August 2, 2016

**RE: University Of New England  
Stevens Avenue Armory Renovations  
772 Stevens Avenue  
Building Permit Application – Response to Staff Comments**

**FIRST AND
 SECOND
 FLOOR
 PART PLANS**

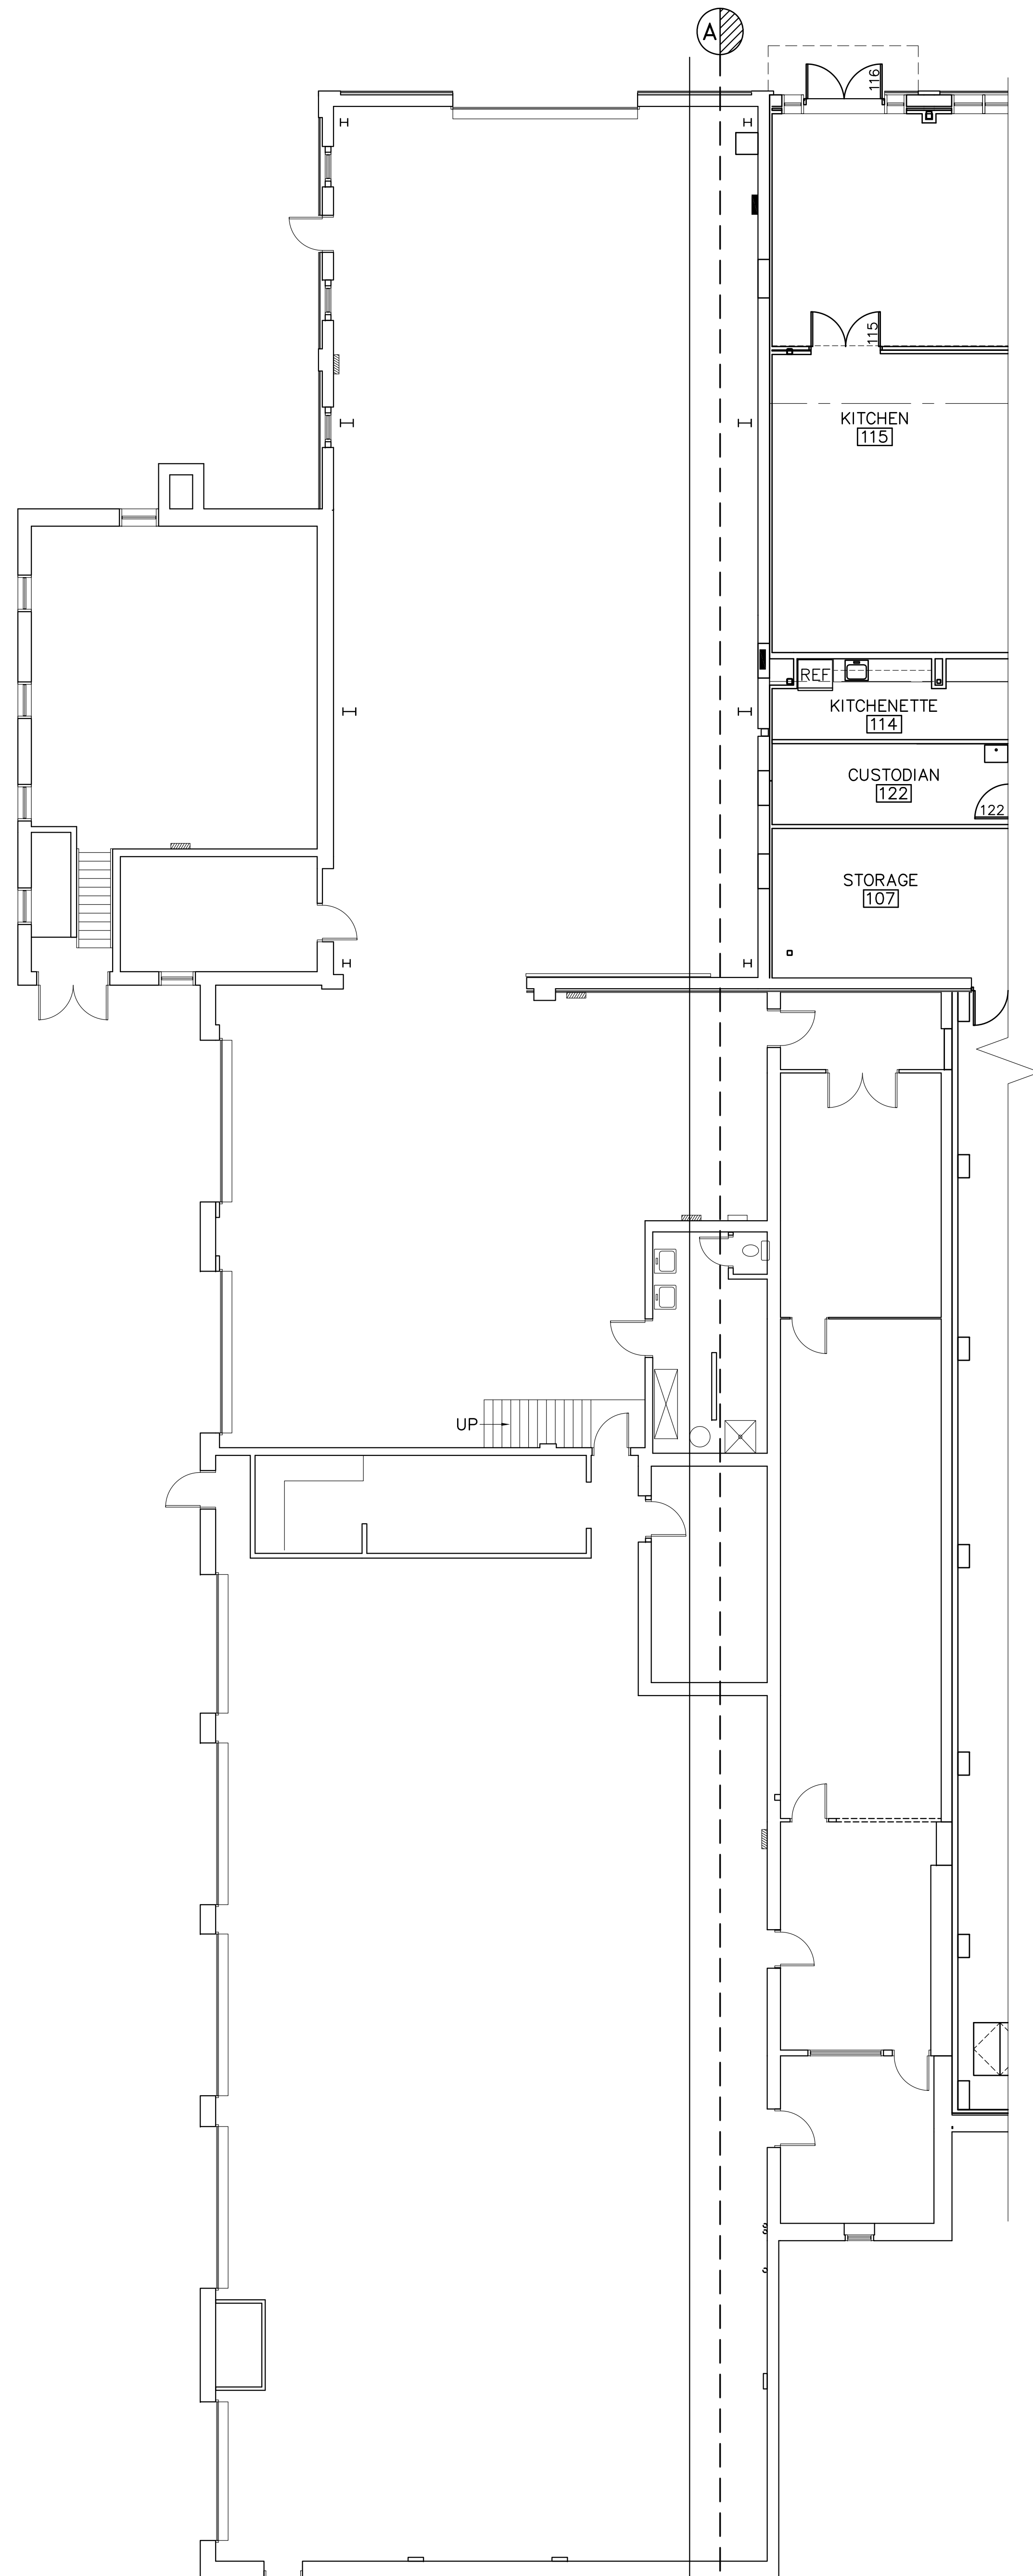
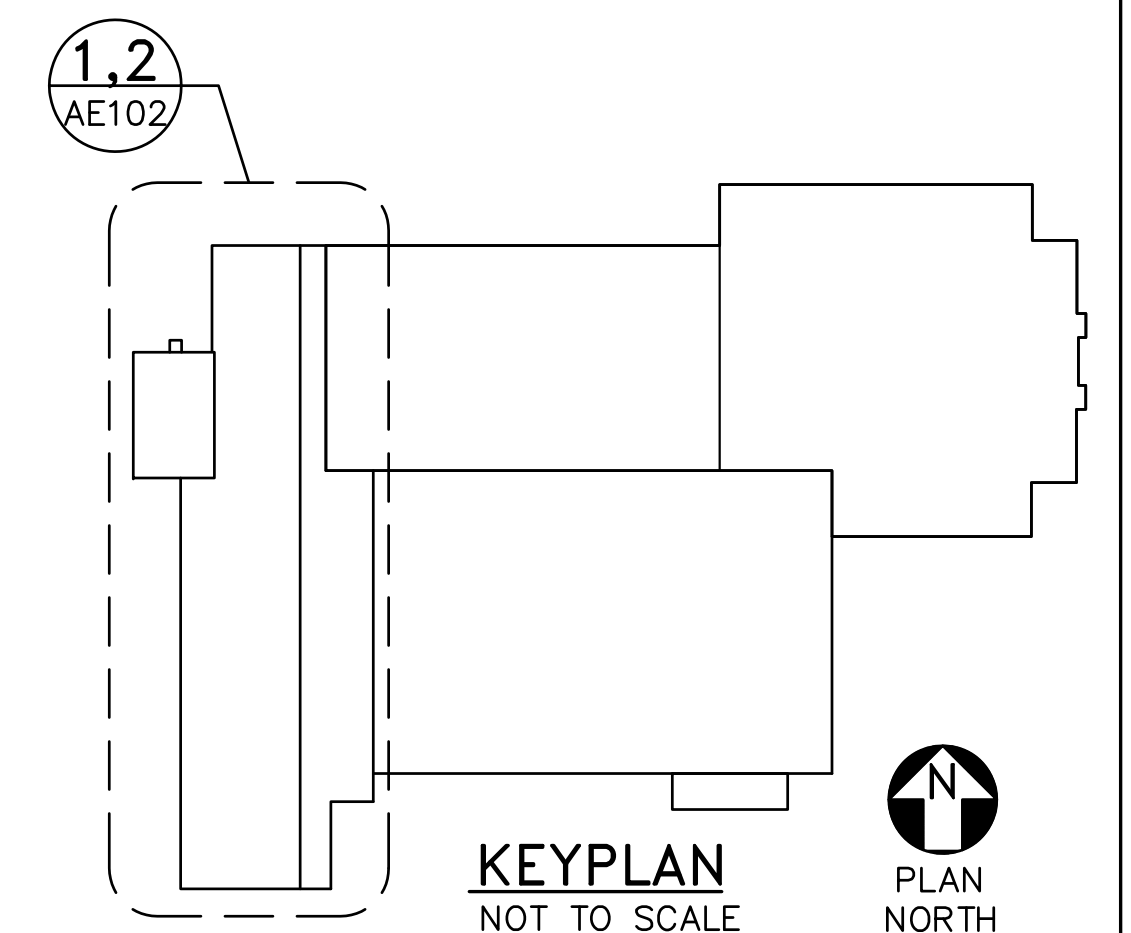
In response to the question related to ADA compliance, specifically as it related to the *2010 ADA Standards for Accessible Design, Chapter 2, Section 226, Dining and Work Surfaces*, we offer the following:

The University of New England is well versed in the *2010 ADA Standards for Accessible Design* and adheres to these guidelines. All of the workstations illustrated on the plans are intended for use by employees of the University. The University has taken great care to insure that the majority, significantly more than the 5% required, of the office workstations will be modular and easily adjustable from a seated to a standing position, thus can accommodate any person's needs, including those with disabilities.

As this relates to Dining Surfaces, the University's "kitchen" is essentially a warming kitchen for events only. The events will be primarily furnished with rental tables and chairs. Our invitations often include inquiries for accommodations, and the University will insure that at least 5% of these seats will accommodate the persons with disabilities, as per *Section 226*.
